Application for Planning Permission for Works or Extension to a Dwelling

Development: Garage Conversion
Location: 1 Drift Road Ferring BN12 6RD

I regret that I am unable to accept your documents as a valid application until the following item(s) have been received or resolved :-

1 Drift Road, BN12 6RD

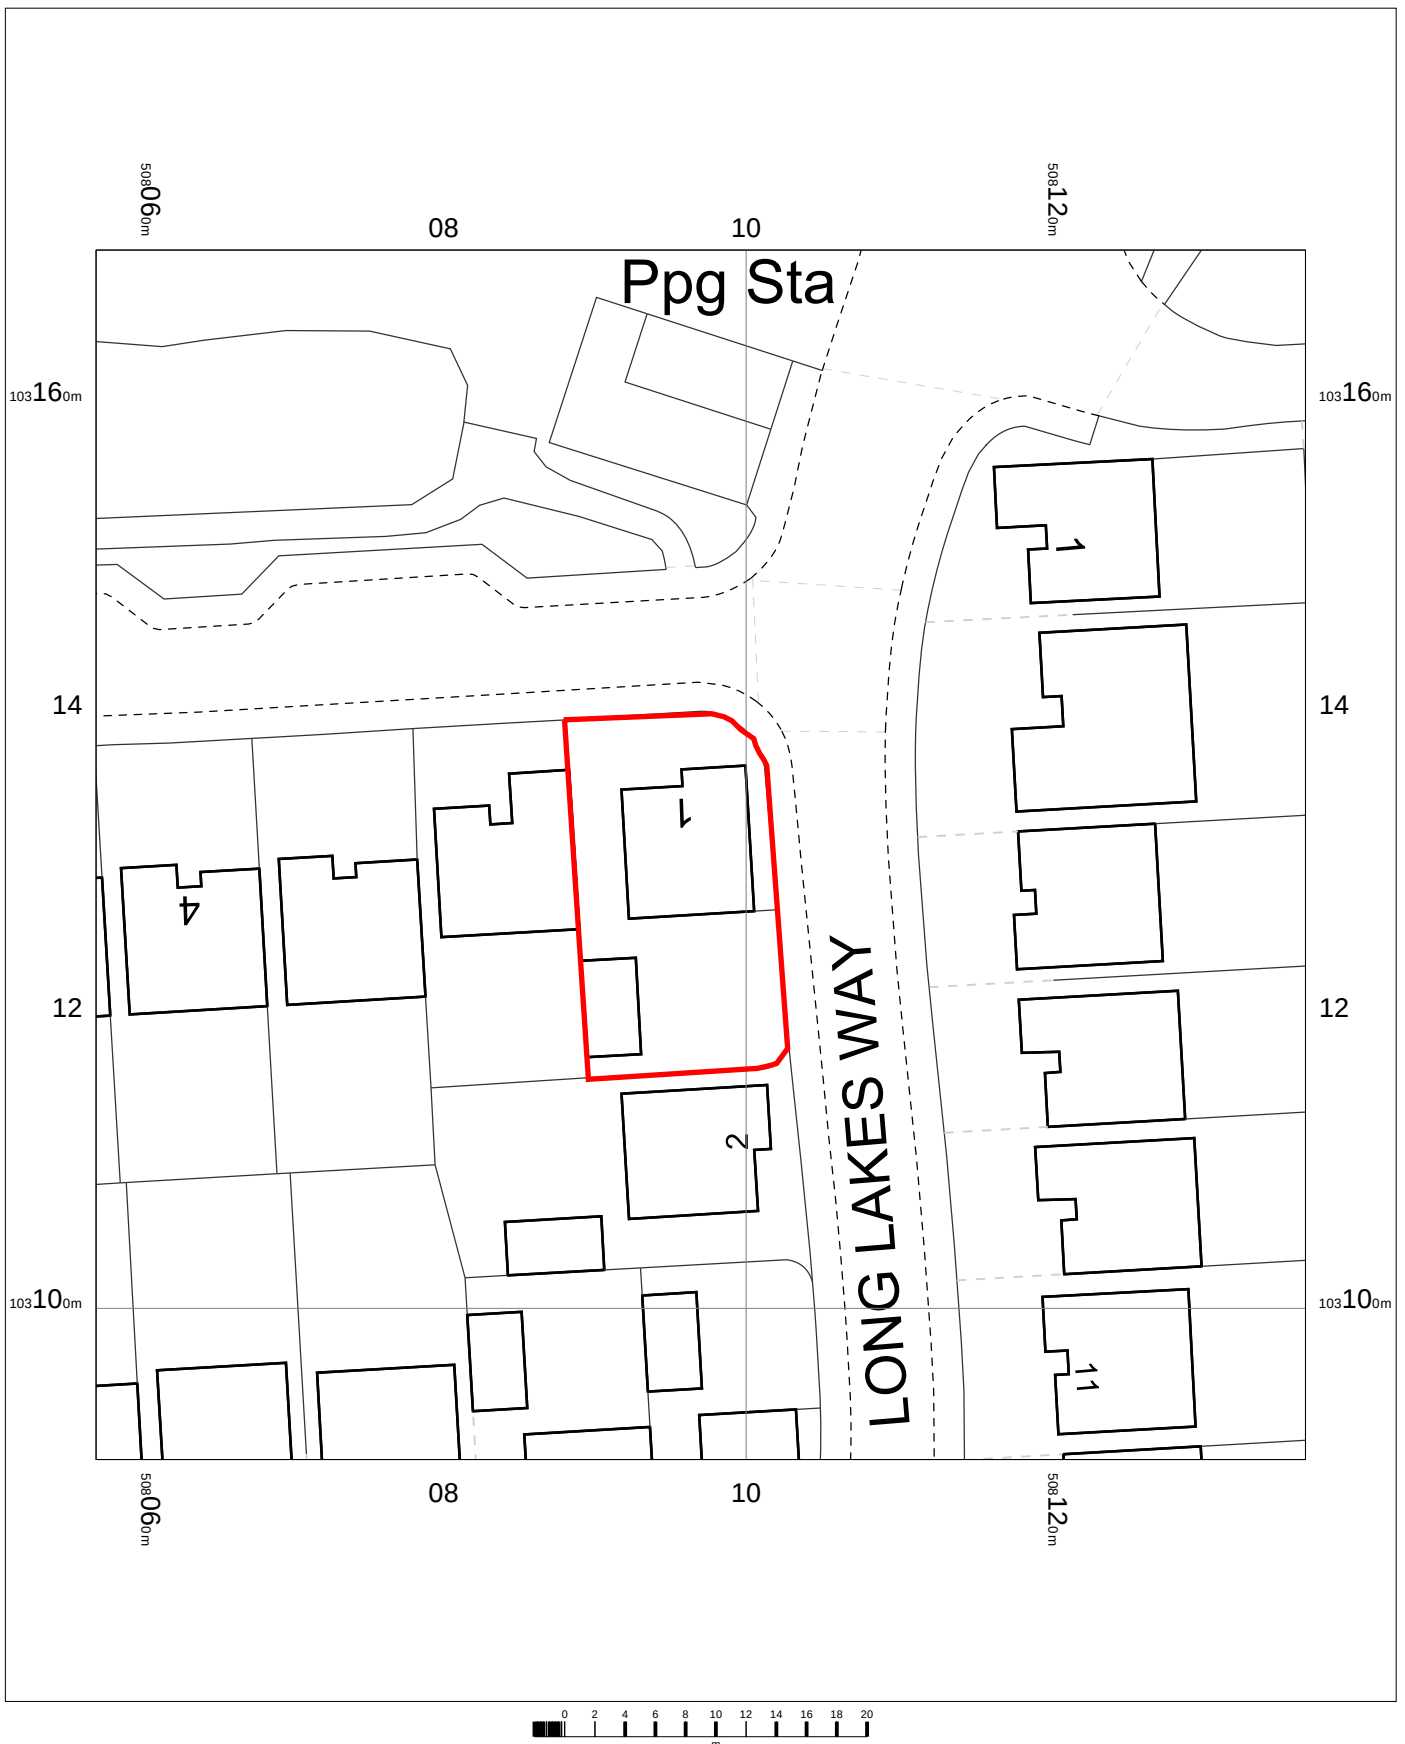
The detached garage is not shown in the location or block plan.

Drawing Title Existing / Proposed Plan

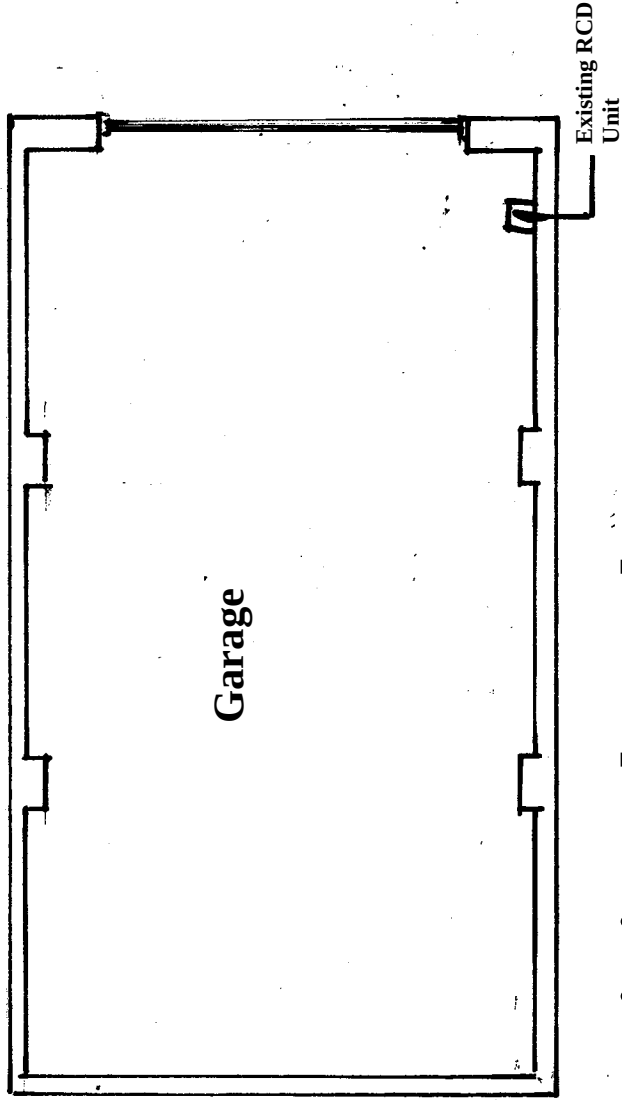
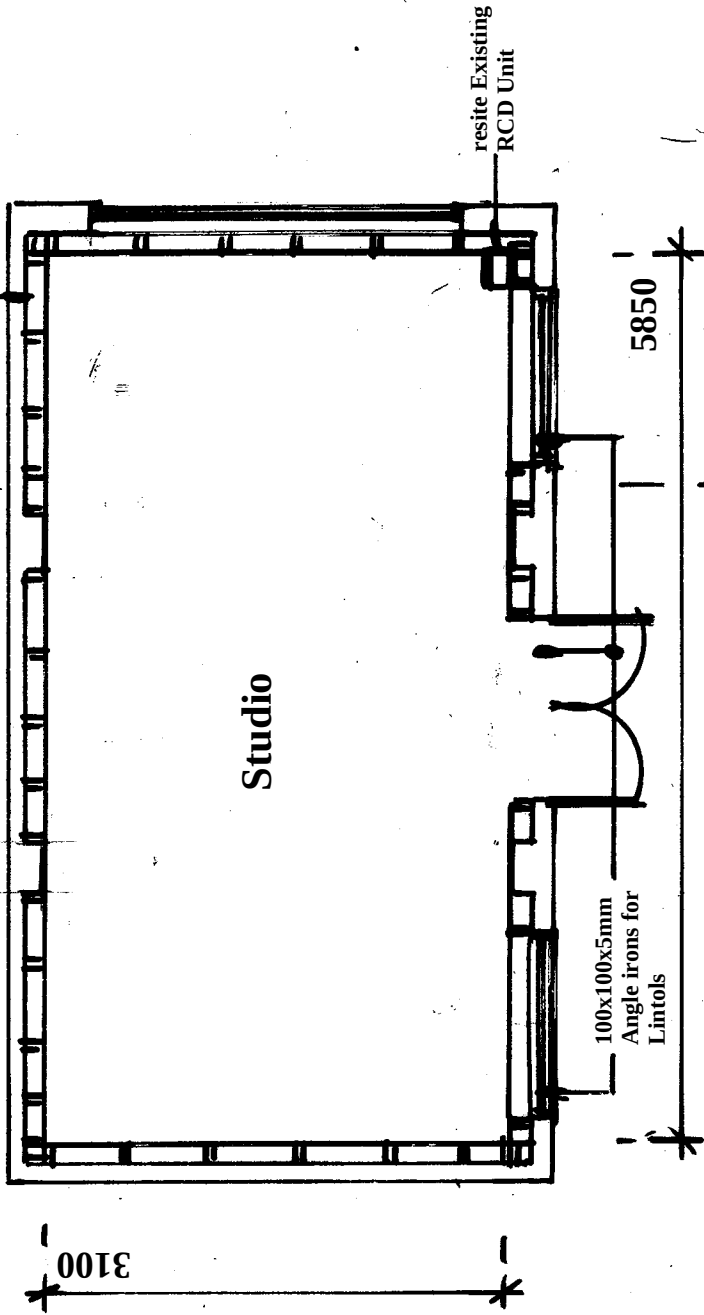
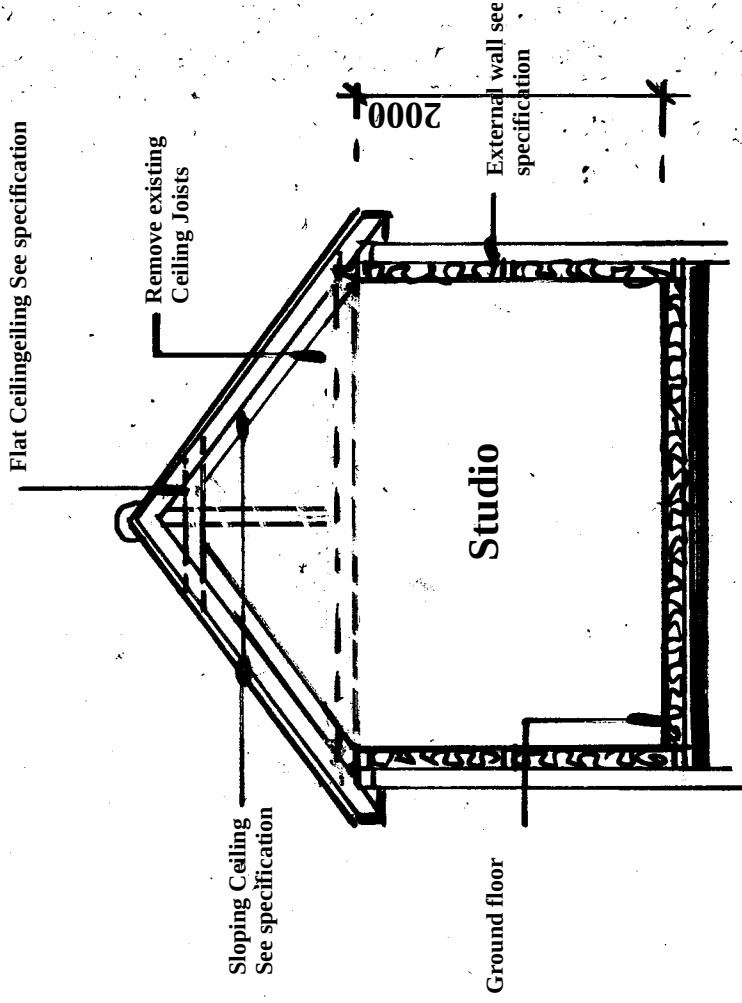
The floor plans require a scale bar.

Proposal	Garage Conversion		
Drawing Title	Existing / Proposed Elevations		
Date	19/07/26	Drawn	S. Burrows
Scales	1:100 on A3		
DWG NO.	S13552/2	REV

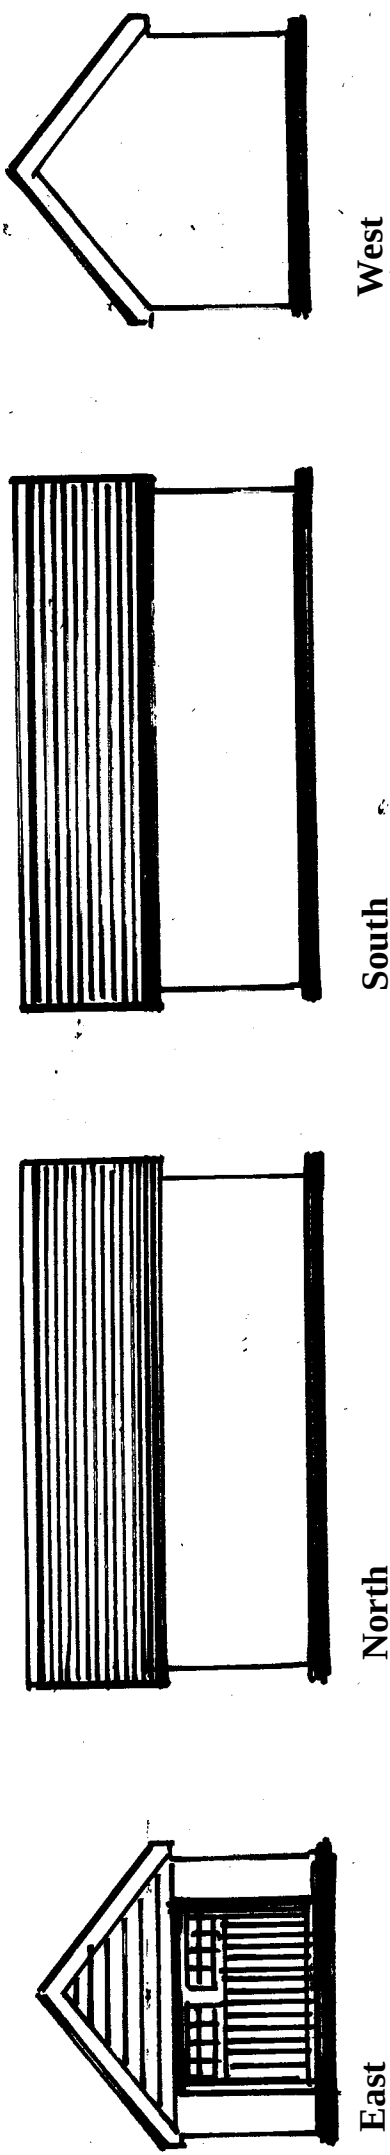
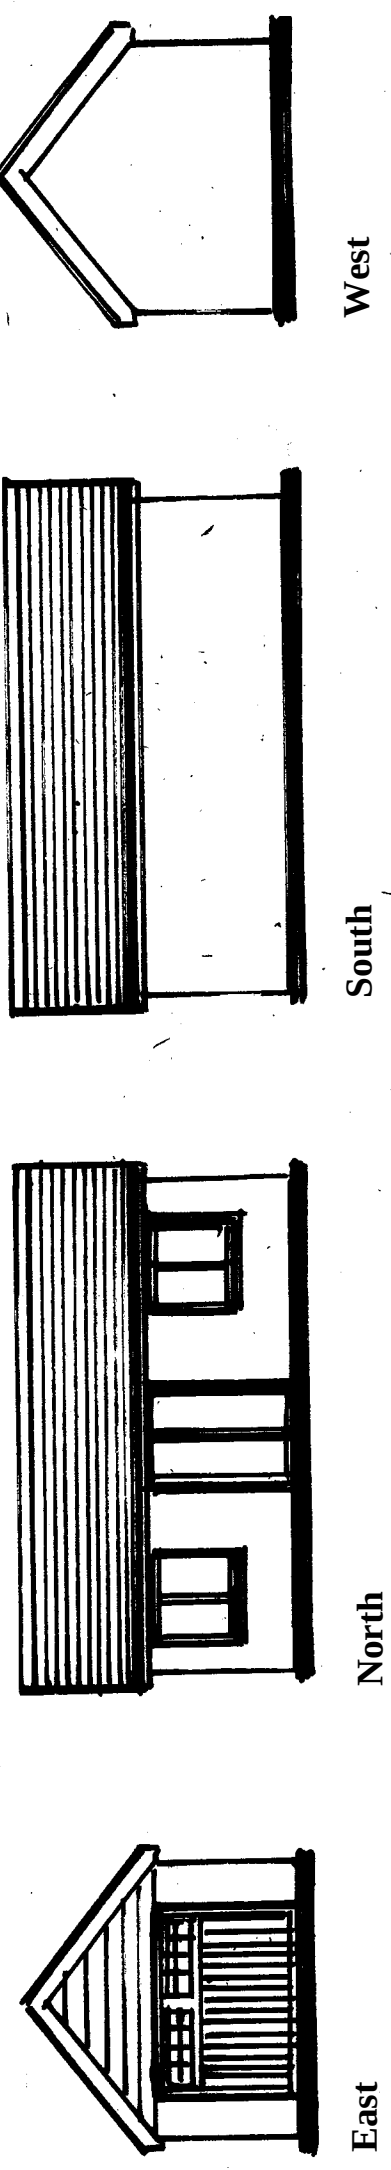
The provided elevation plans require a scalebar.
